STERLING RANCH EAST FILING NO. 5

PRELIMINARY PLAN

STERLING RANCH EAST FILING NO. 5
PRELIMINARY PLAN
TITLE SHEET

STERLING RANCH EAST FILING NO. 5
PRELIMINARY PLAN
 LEGAL BOUNDARY EXHIBIT &
 ADJACENT OWNERS

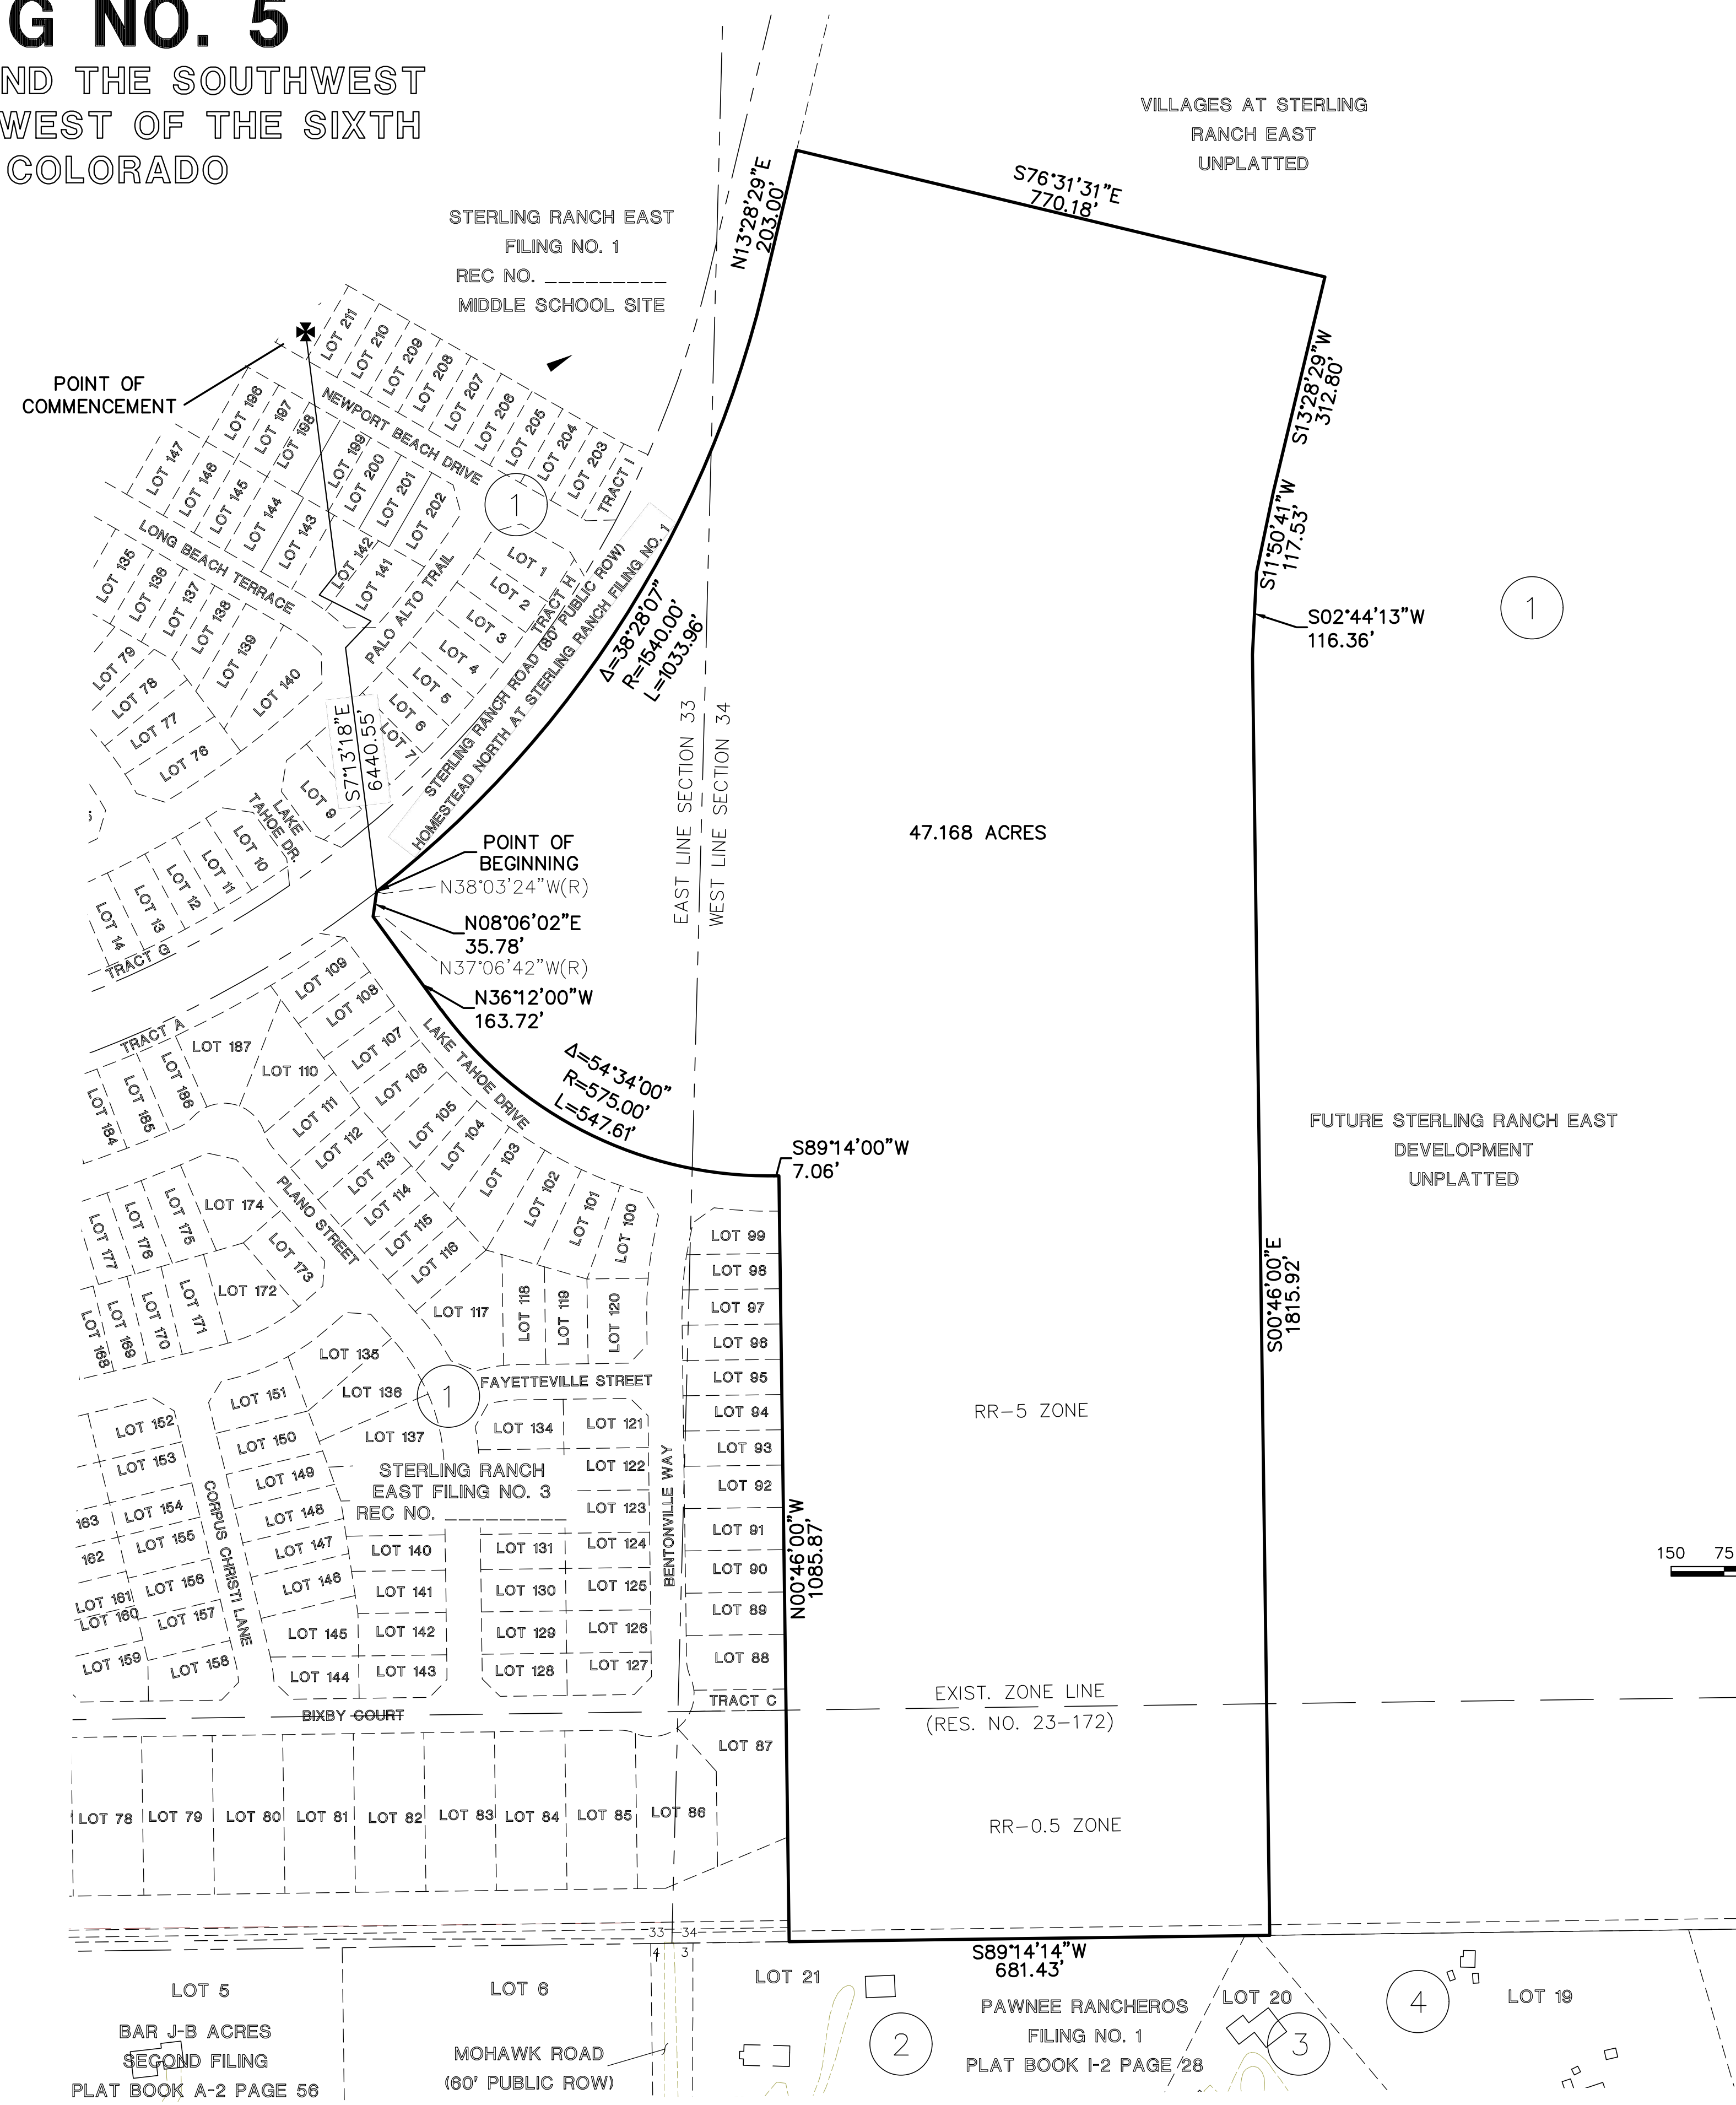
normally a legal would be immediately after this

Section 7.2.5 of the LDC.
Exterior boundary description of subject property graphically depicted and a written legal description tied to a survey monument.

repeat comment- all sheets need title info

STERLING RANCH EAST FILING NO. 5 PRELIMINARY PLAN			
	DESIGNED BY	ESO	SCALE	DATE 05/12/2023
	DRAWN BY	ESO	(H) 1" = 50'	SHEET 5 OF 21
	CHECKED BY		(V) 1" = N/A	JOB NO. 1183.25

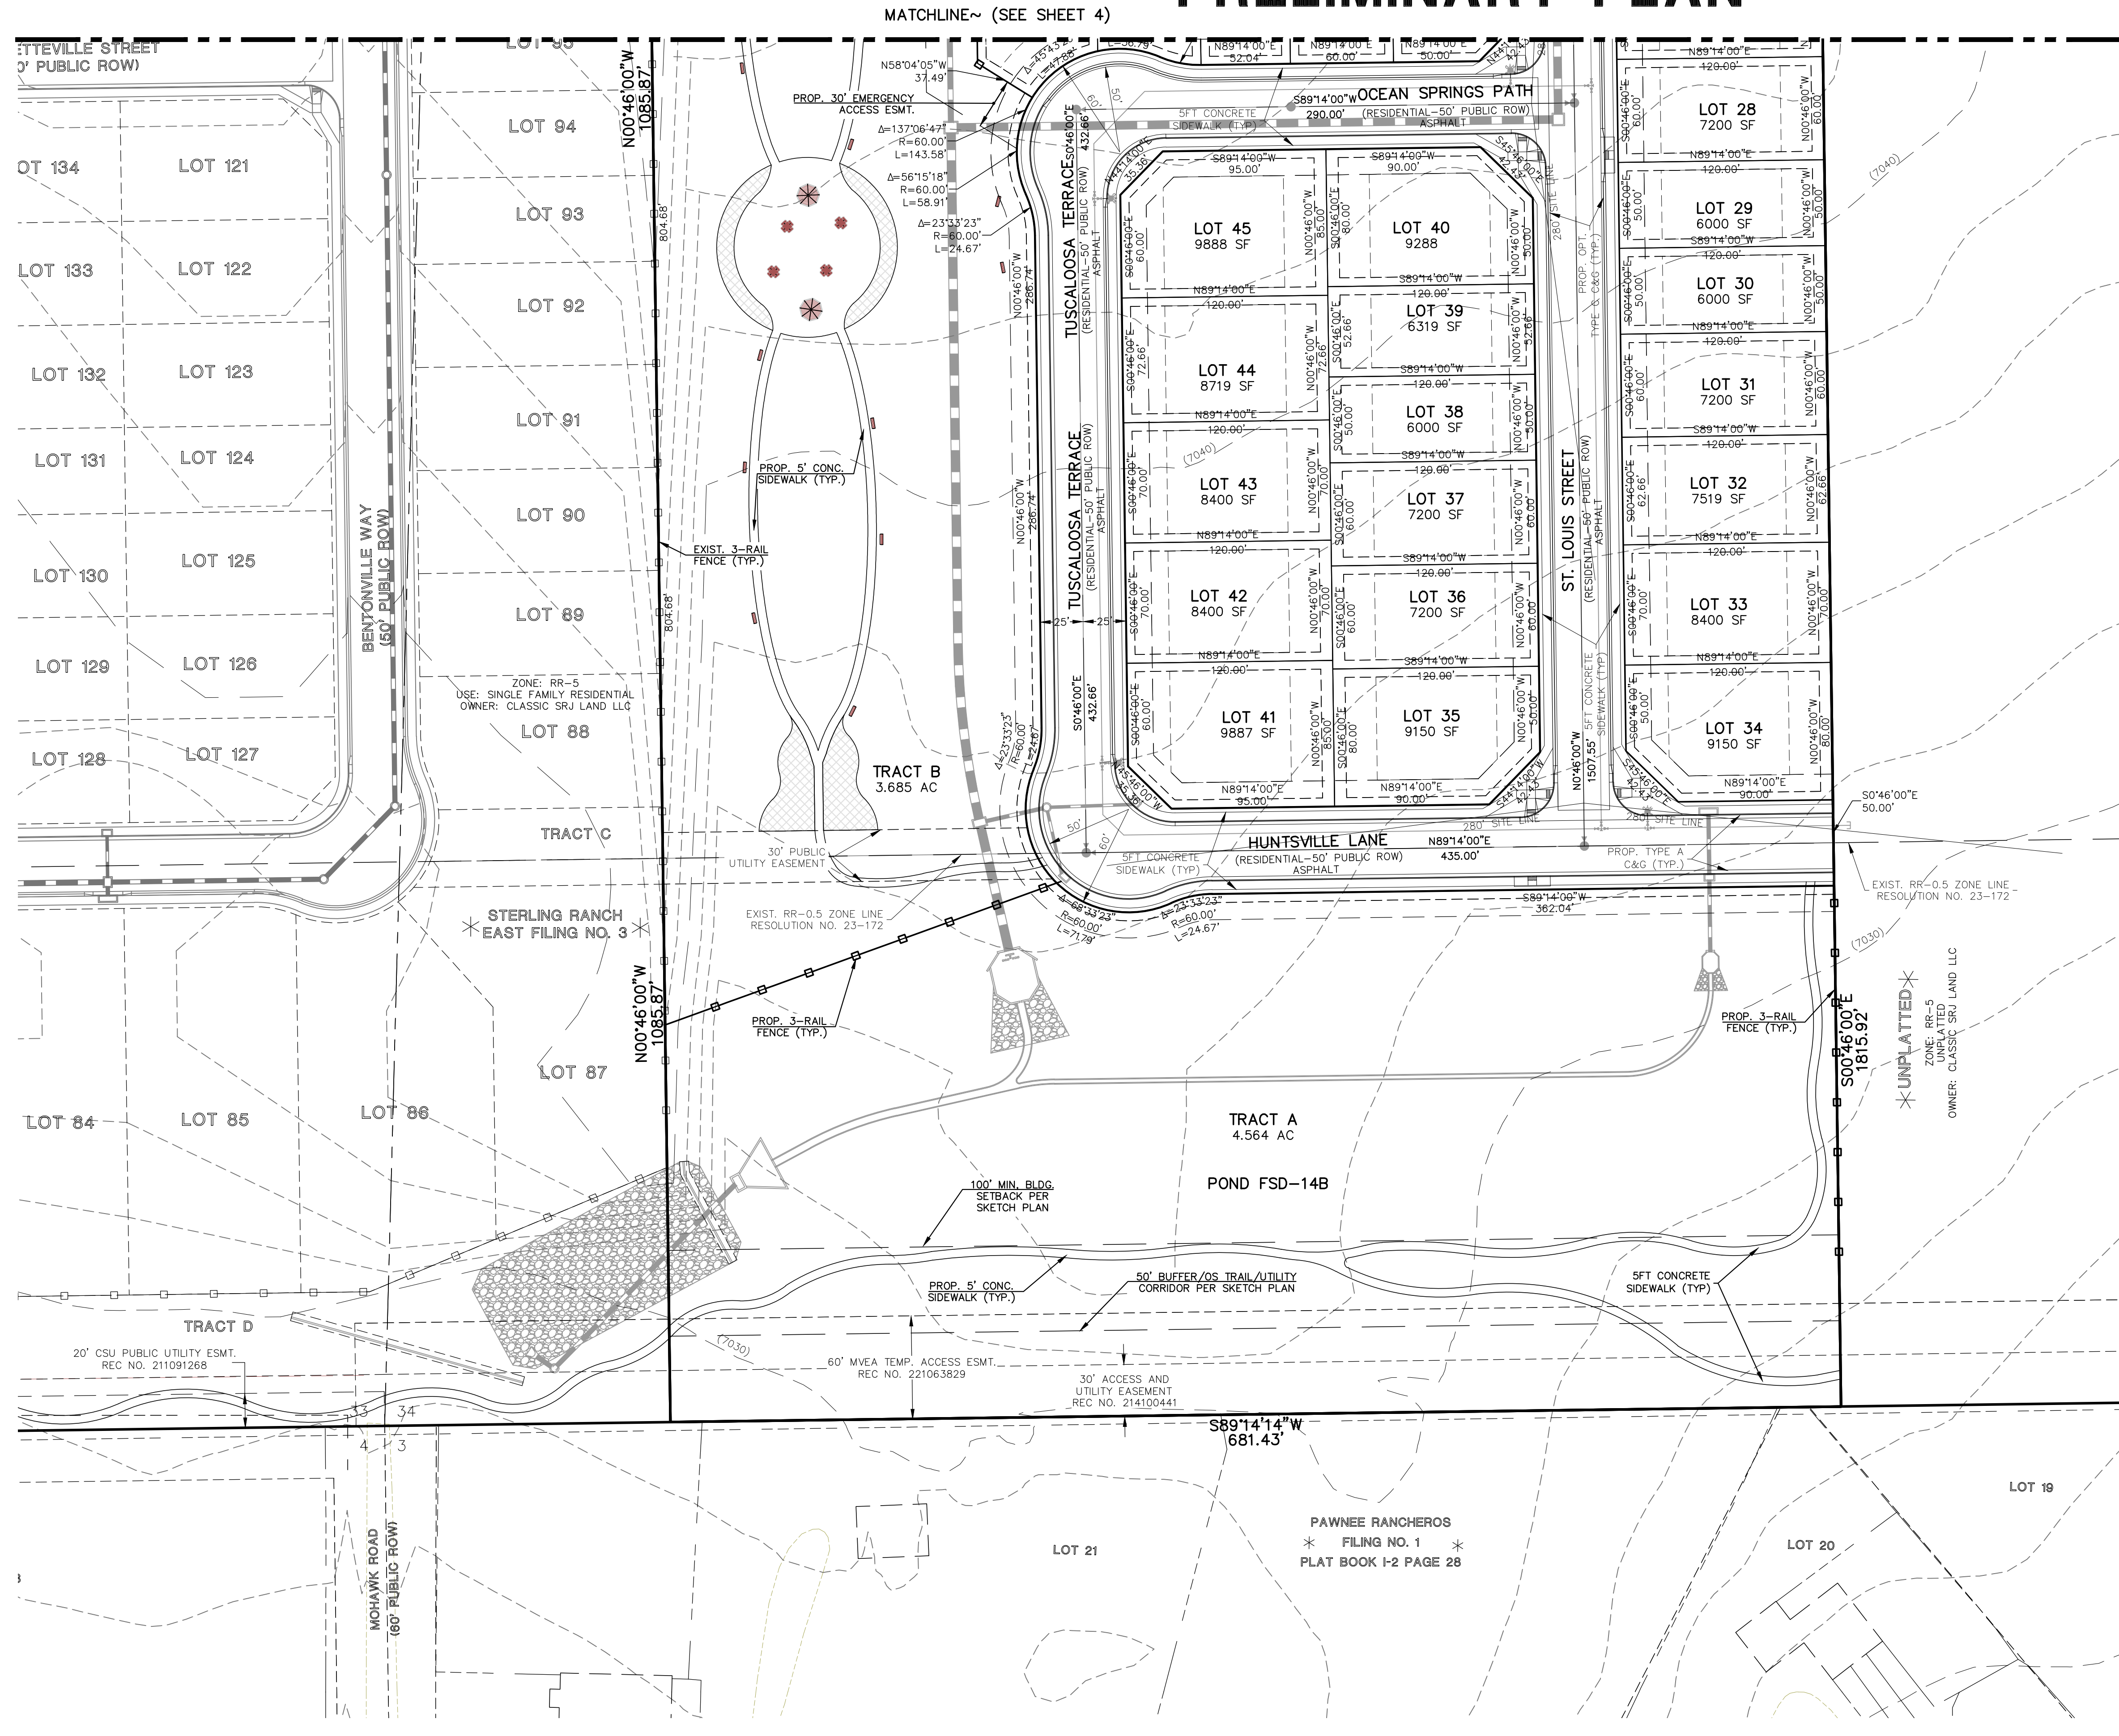
Preliminary plan title block on all sheets
please- repeat comment required per checklist
